**WELWYN HATFIELD BOROUGH COUNCIL  
EXECUTIVE DIRECTOR - PLANNING, PUBLIC PROTECTION AND GOVERNANCE**

**DELEGATED APPLICATION**

**Application No:** 6/2021/2279/HOUSE  
**Location:** 67 Bramble Road Hatfield AL10 9SA  
**Proposal:** Erection of a single storey side and rear extension  
**Officer:** Ms Elizabeth Mugova

**Recommendation:** Granted

Proposed Block Plan @ 1:200

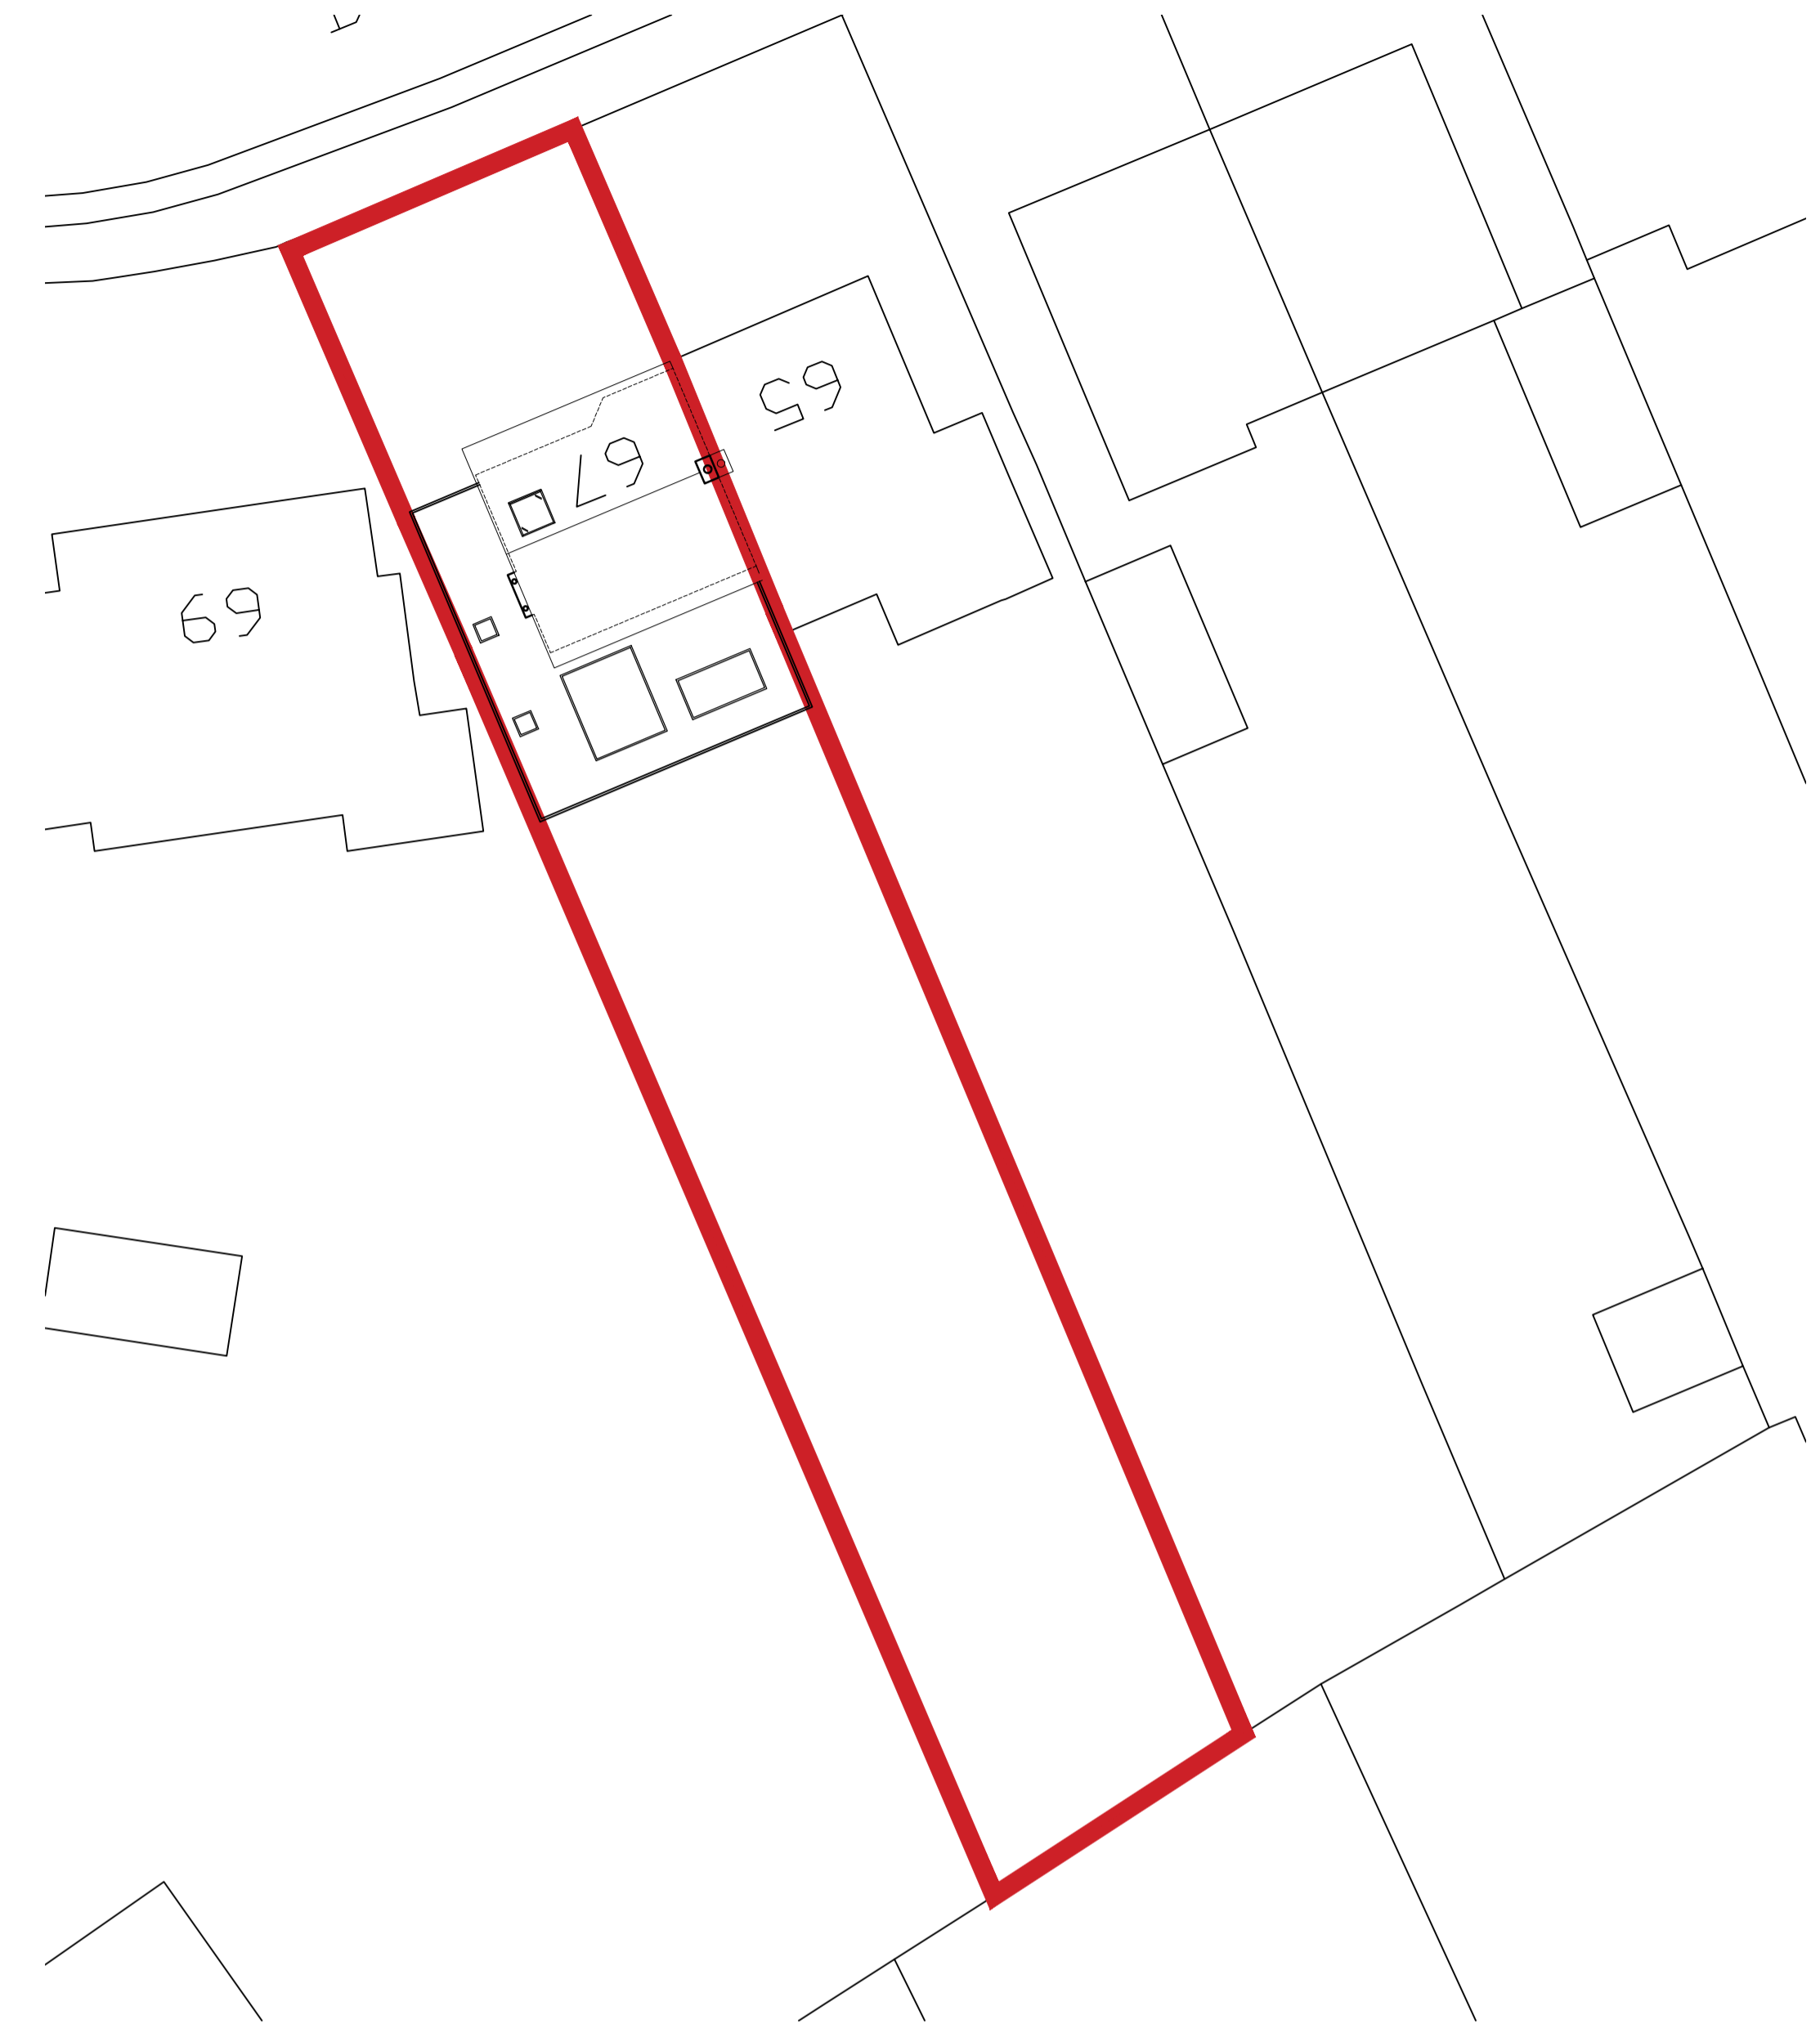
Whilst the submitted block plan does not show off-street parking spaces, it was observed during a site visit that the frontage is large enough to accommodate parking for at least two vehicles. For these reasons, there is no objection on the grounds of parking.

Ground Floor Plan @ 1:50

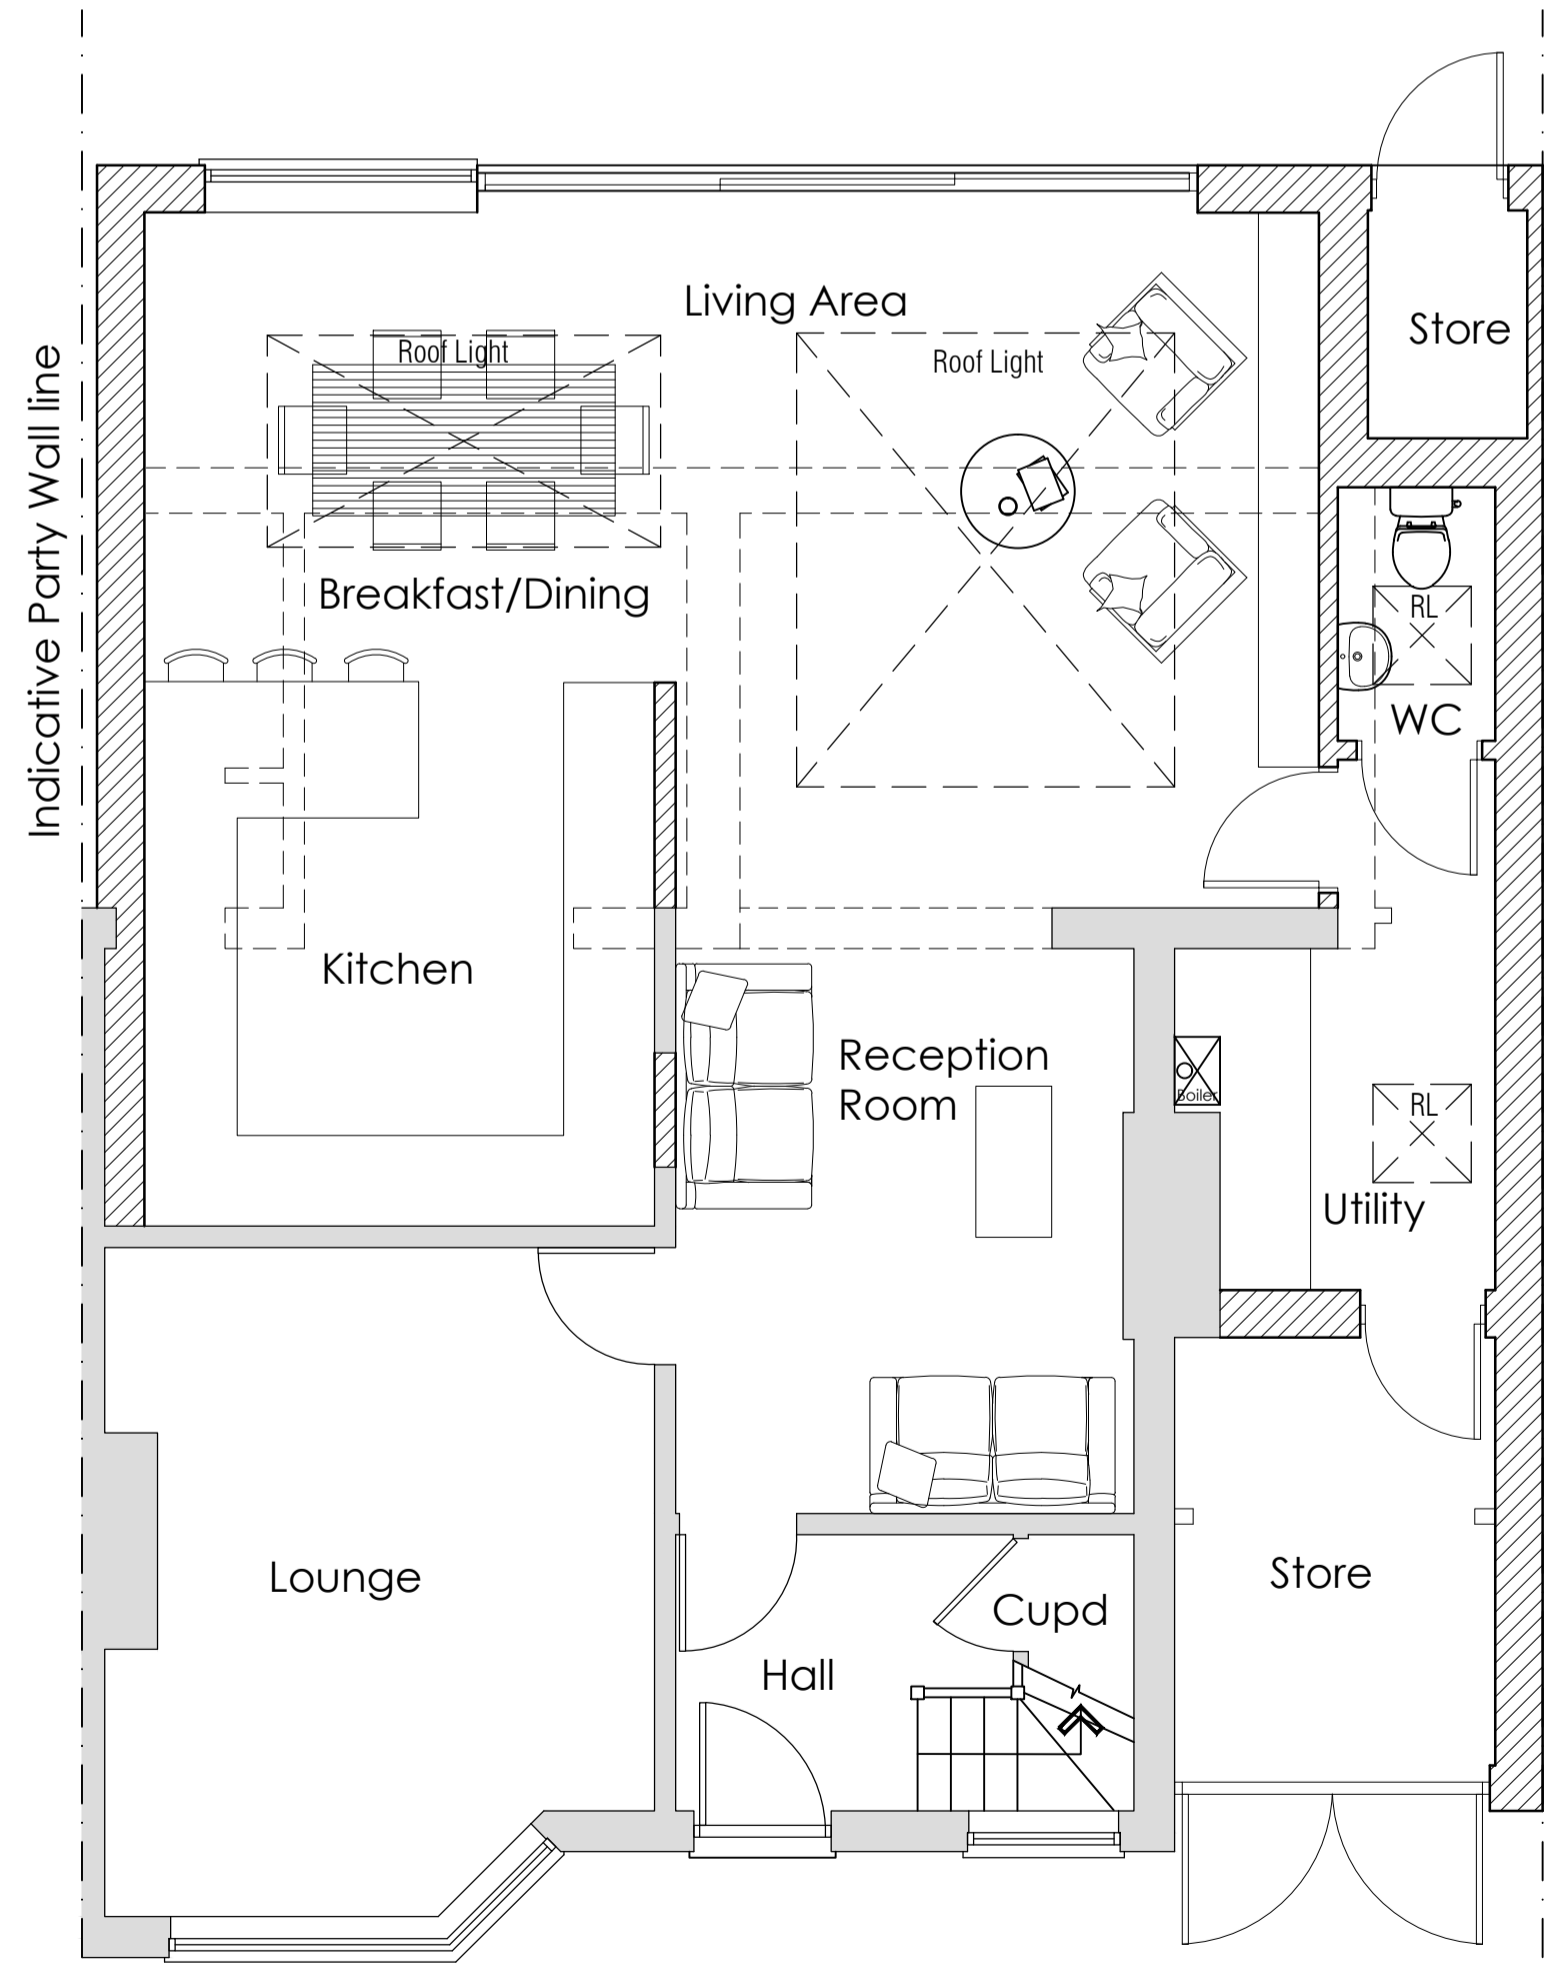
<p><u>69 Bramble Road</u> The submitted plans do not accurately represent the conditions on the ground as they:</p> <ul style="list-style-type: none"> <li>• Fail to depict the correct location of the boundary between neighbouring houses number 67 &amp; 69. If the extension is constructed as proposed it will cross the boundary into the neighbouring property.</li> <li>• The plans also fail to accurately depict the relative position of properties 67 &amp; 69 such that the front aspect of the proposed side extension will protrude beyond the frontage of the neighbouring property, in the plans it is depicted as finishing behind.</li> <li>• The proposed works will also have a significant impact on the visual appearance of the two properties as the proposed extension will be constructed up to the very limit of the legal boundary at the narrowest point between the two houses. The extension will also both visually and physically narrow the existing side access for number 69.</li> </ul>

On the other hand, the neighbour at No. 69 has raised an objection with regards to significant impact on the visual appearance of the two properties as the proposed extension will be constructed up to the very limit of the legal boundary at the narrowest point between the two houses. They are also concerned that the extension if constructed as proposed, it will cross the boundary into their property. However, the submitted existing and proposed ground floor plans (Drawing No 01 and Drawing No 200a respectively) show that the width of the extension at the front will remain the same i.e. 2.4 metres. This demonstrates that the existing side garage/utility is built up to the boundary and the replacement will follow the same boundary line. Subject to a planning condition regarding development being carried in accordance with the proposed ground floor plans it is considered that the design of the extension would not cross the boundary of No. 69.
